**APPEAL AGAINST CHERWELL DISTRICT COUNCIL FOR THE
DEVELOPMENT OF**

**LAND AT NORTH WEST BICESTER, CHARLOTTE AVENUE,
BICESTER, OX27 8BP**

REBUTTAL PROOF OF EVIDENCE

PLANNING INSPECTORATE REFERENCE: APP/C3105/W/23/3315849
CHERWELL DISTRICT COUNCIL REFERENCE: 21/01630/OUT

Diagram:
2 - Rev A

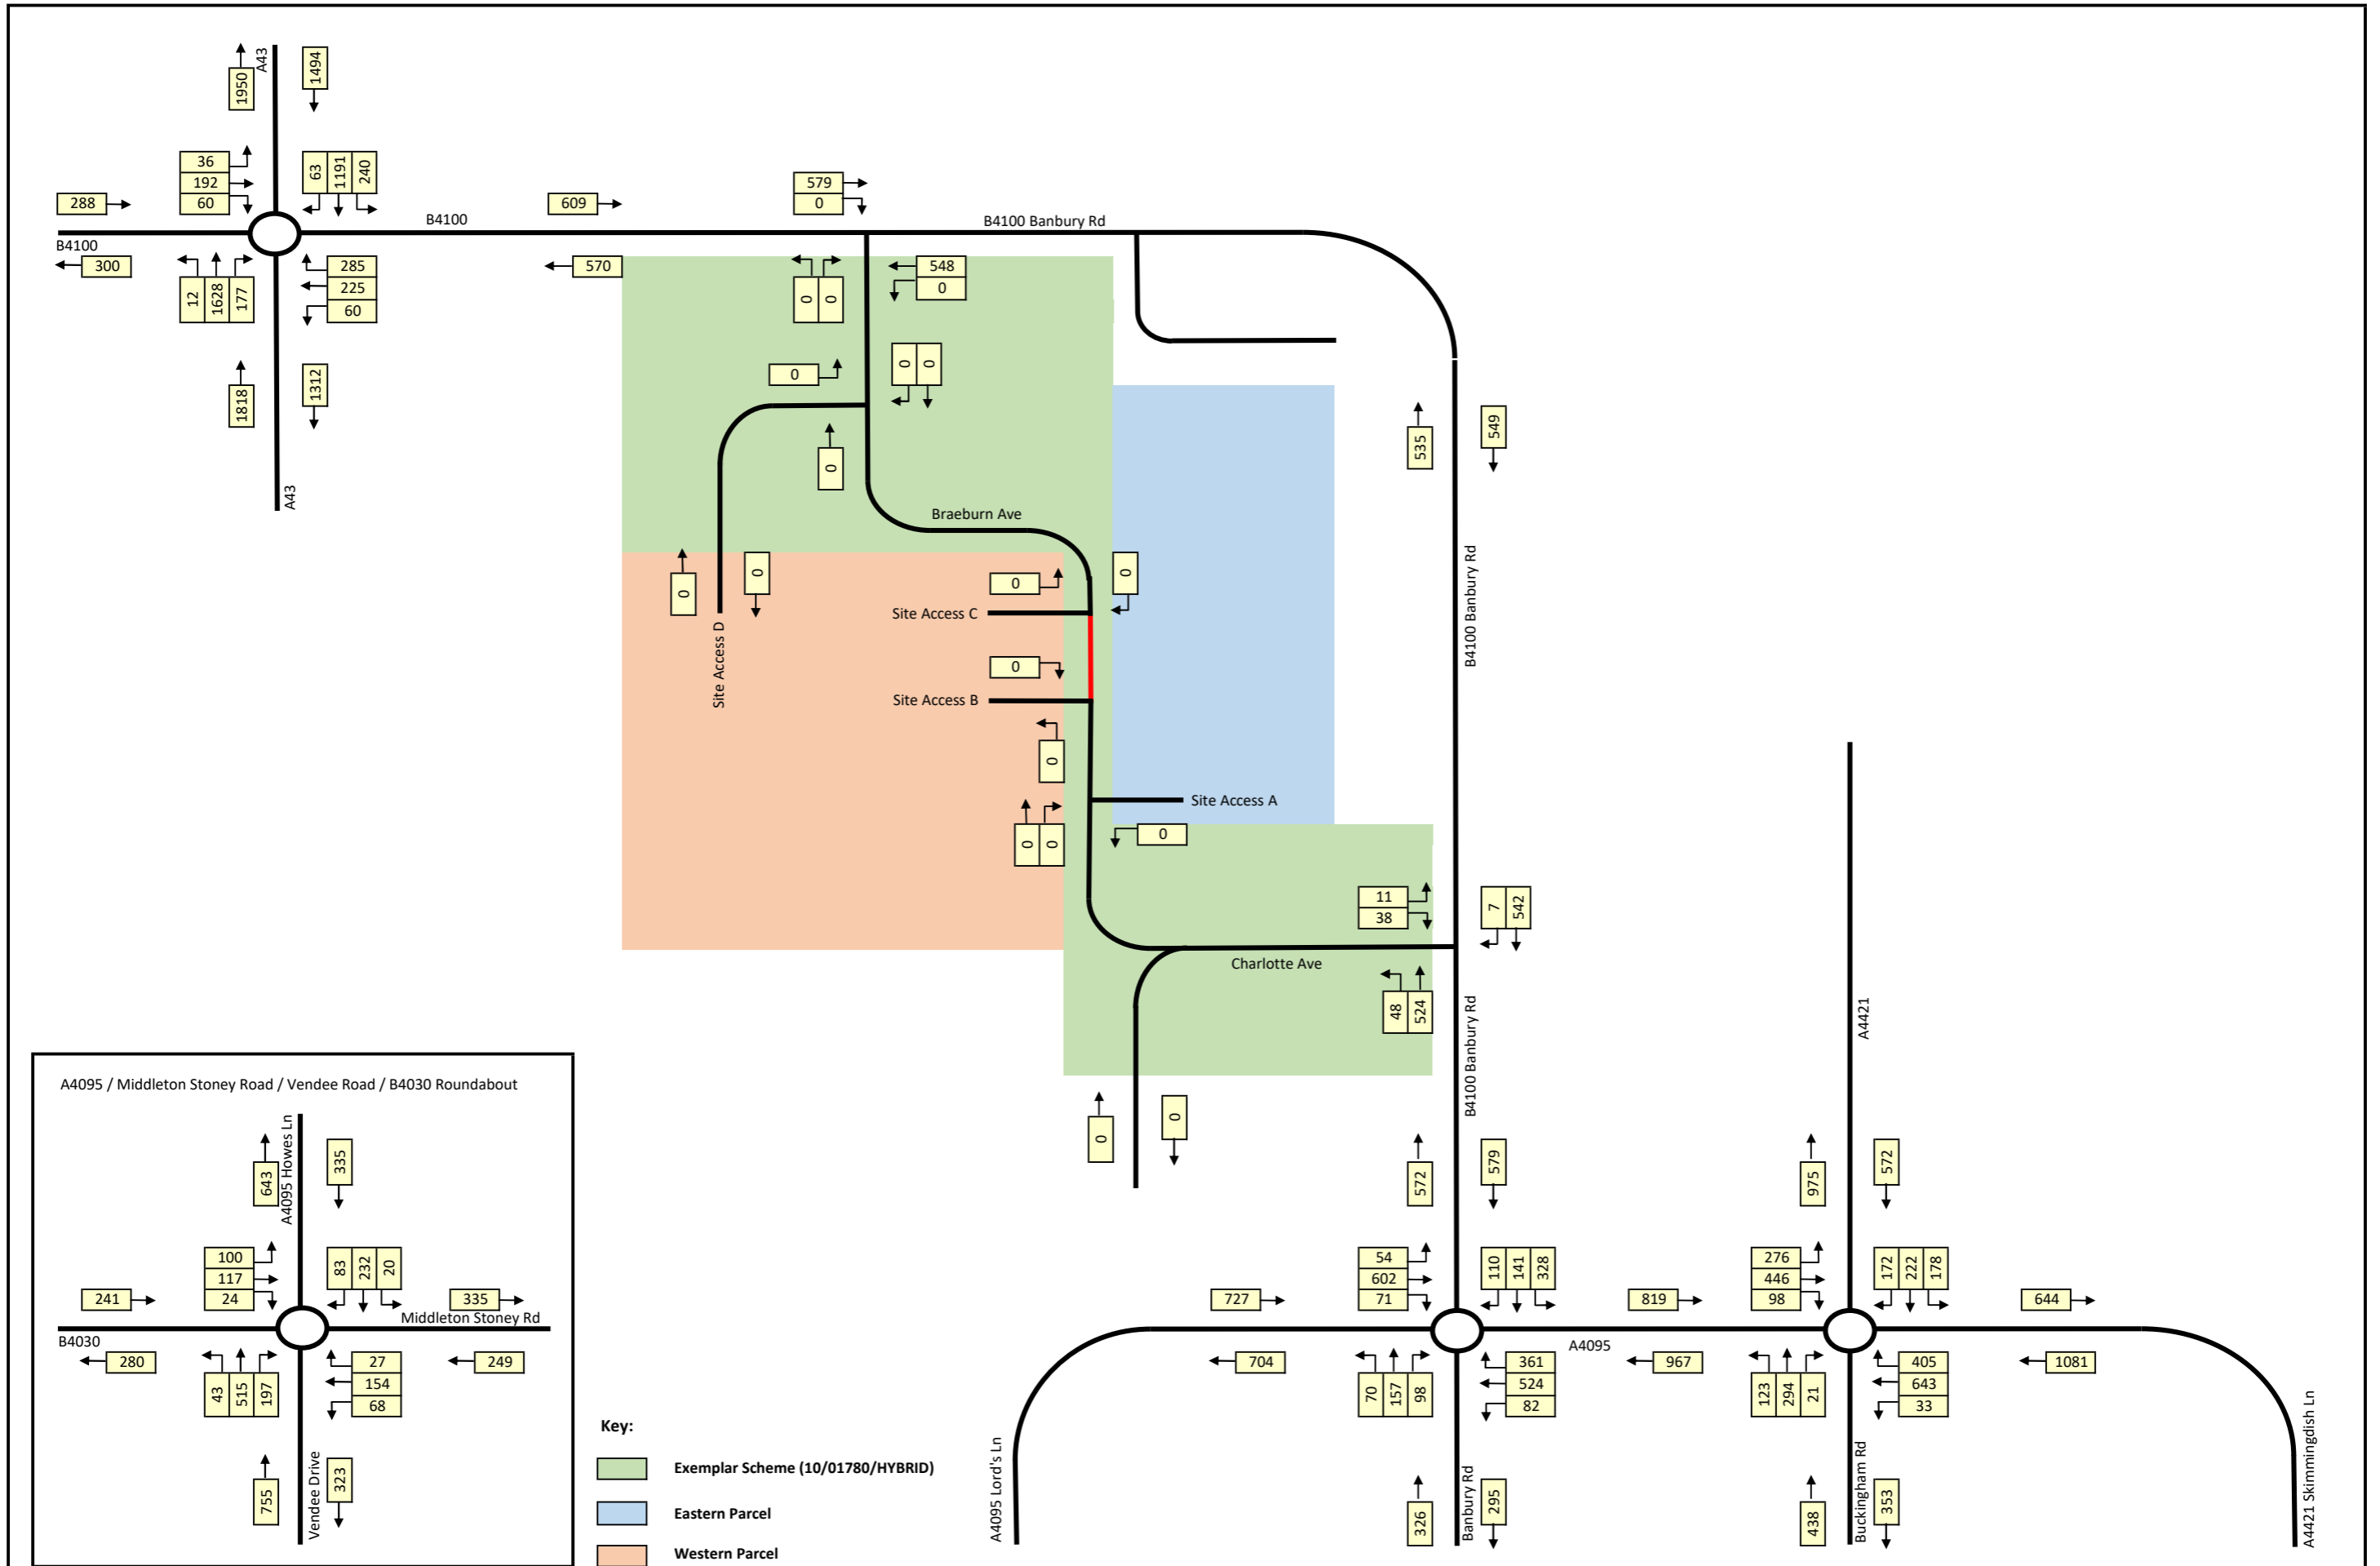
- (a) Diagrams 1 & 2 – 2016 Base Traffic Flows
- (i) The 2016 BTM (Bicester Transport Model) traffic flows included junction movements at the B4100 Banbury Road junctions with Braeburn Avenue and Charlotte Avenue, and these flows are included in Diagrams 1 & 2.

- (ii) The existing Exemplar Development included a total of 393 dwellings, of which Phase 1 (94 dwellings) and Phase 2 (72 dwellings) would be accessed from Charlotte Avenue only. There are no alternative means of vehicular access for vehicles using Charlotte Avenue as the bus gate between Charlotte Avenue and Braeburn Avenue prevents through movements, other than for buses and non-motorised users.

- (iii) Diagrams A & B have been prepared to demonstrate the level of permitted vehicular activity associated with the Exemplar Development using the same agreed trips rates, distribution profile, and proportionate split of private and affordable housing as was used for the Proposed Development.

- (iv) The negative traffic flows that are identified near Cranberry Avenue are a simple calculation whereby the 2016 BTM traffic flows are considered against the permitted Exemplar Development traffic flows. As it is acknowledged that negative traffic flows are not possible, the revised 2016 Base Traffic Flow diagrams do not reference these negative flows along Cranberry Avenue.

- 4.4 Mr Mason has identified in paragraphs 5.5 to 5.9 of his PoE a number of discrepancies within the Traffic Flow Diagrams that were included in Appendix F of the TA [CD-1-28.2]. For clarity, these discrepancies are addressed below, and a revised set of Traffic Flows is included in **ATTACHMENT B** of this rebuttal. It must be noted that none of these perceived discrepancies will have any material impact on the technical work undertaken to date.

Date:
30/05/2023
Diagram:
5 - Rev A

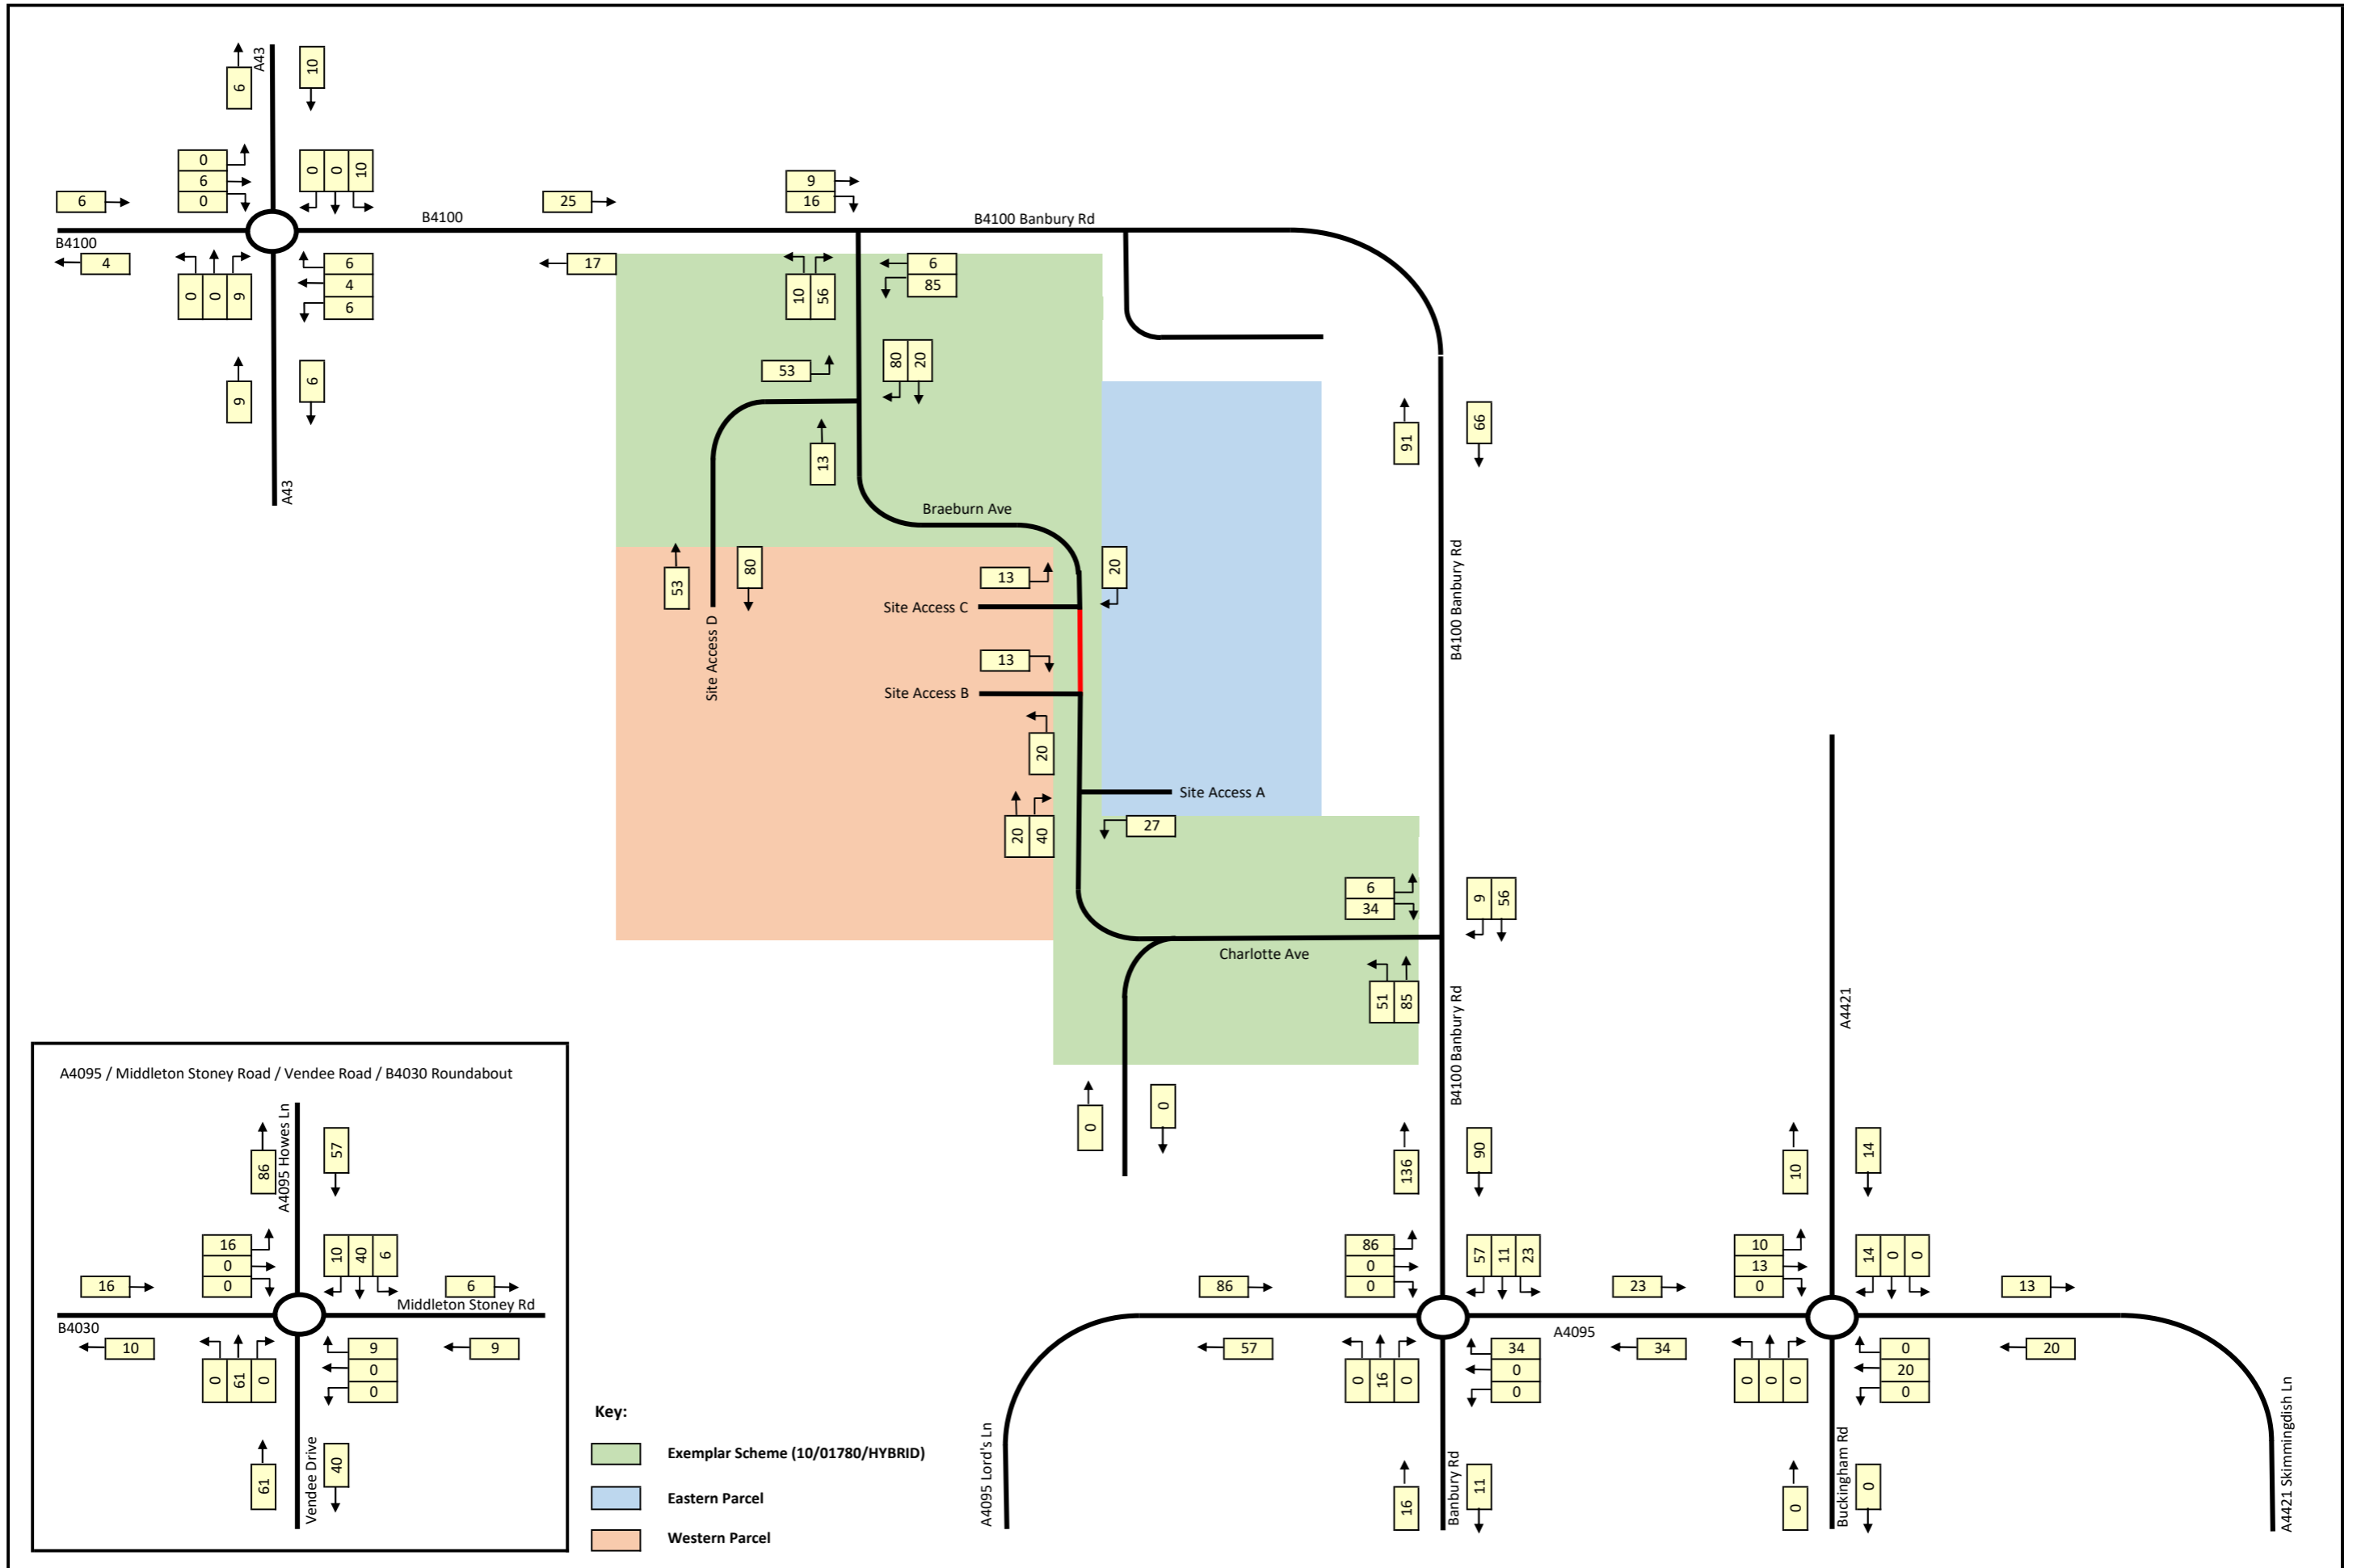
- (i) Mr Mason acknowledges in paragraph 5.25 of his PoE that a typographical error may have been made in relation to the arrival trips at Proposed Site Access D, which identifies that no vehicles would arrive at this access in the AM or the PM peak hour period.

- (ii) This is acknowledged to be a typographical error, and attention is drawn to the fact that the full complement of vehicle movements is identified at the B4100 Banbury Road/Braeburn Avenue junction.

- (iii) For ease of reference, Diagrams 4 & 5 have been updated to correct this typographical error.
 - (d) It is key to note that none of the above subtle revisions to the traffic flow diagrams would have any bearing or impact on the technical assessments undertaken to date.
